Acoustic Review Report

For: Mollett's Farm

Report Reference: B5393 2021-05-11 R

Figure 11A.9 - Sharps Redmore two village bypass sound survey locations

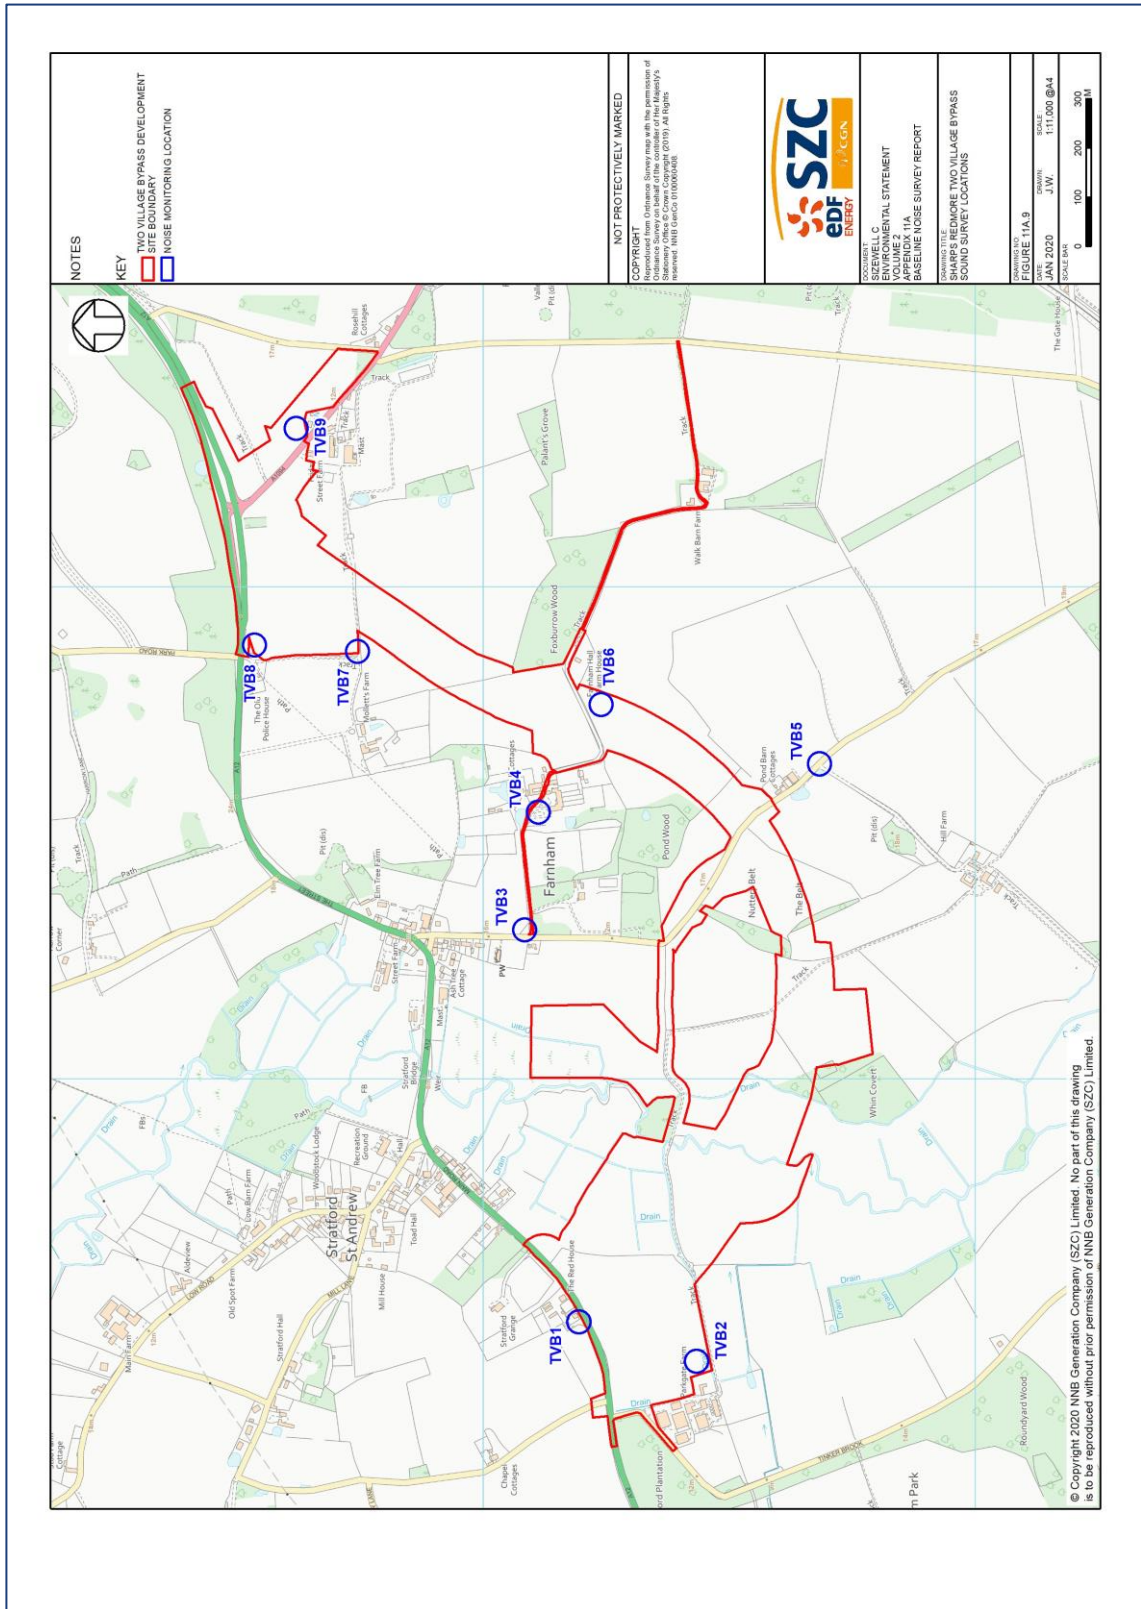
- 5.6 Two of the nine locations were relatively close to Mollet’s Farm, TVB7 and TVB8. The locations of which are shown on the figure below.

Receptor Name	Receptor Reference	Typical Sound Level (day)		Typical Sound Level (night)	
		L _{Aeq,T} (dB)	L _{A90,T} (dB)	L _{Aeq,T} (dB)	L _{A90,T} (dB)
Mollett's Farm	TVB7	46-47	43	-	-
The Old Police House	TVB8	64-66	50-51	57	23

- 5.8 Based on experience of similar locations, and the reports of the guests at the holiday cottages, these levels seem high, particularly those at TVB7. A quiet rural location would typically have sound levels lower than these.
- 5.9 Individual pages giving details of the measurement at each location are included in the annexes to Vol 2 App 11A. For TVB7 and TVB 8 the information provided was as follows.
- 5.10 TVB 7 Mollett's Farm, was on a public footpath east of the farm, and was surveyed on 15 May 2019. The survey notes in the baseline report were:

5.14 Paragraph 5.27 of Vol 2 App 11A stated that weather conditions were recorded for each measurement. But no such information is included in the results or annexes sections of the document.

5.17 This gives a difference between upwind and downwind of the same source of 12 dB. The A12 is a significant source of Ambient sound at Mollett’s Farm. Therefore, without information on the wind conditions present during the monitoring surveys there is no way of determining whether the measured levels are representative.
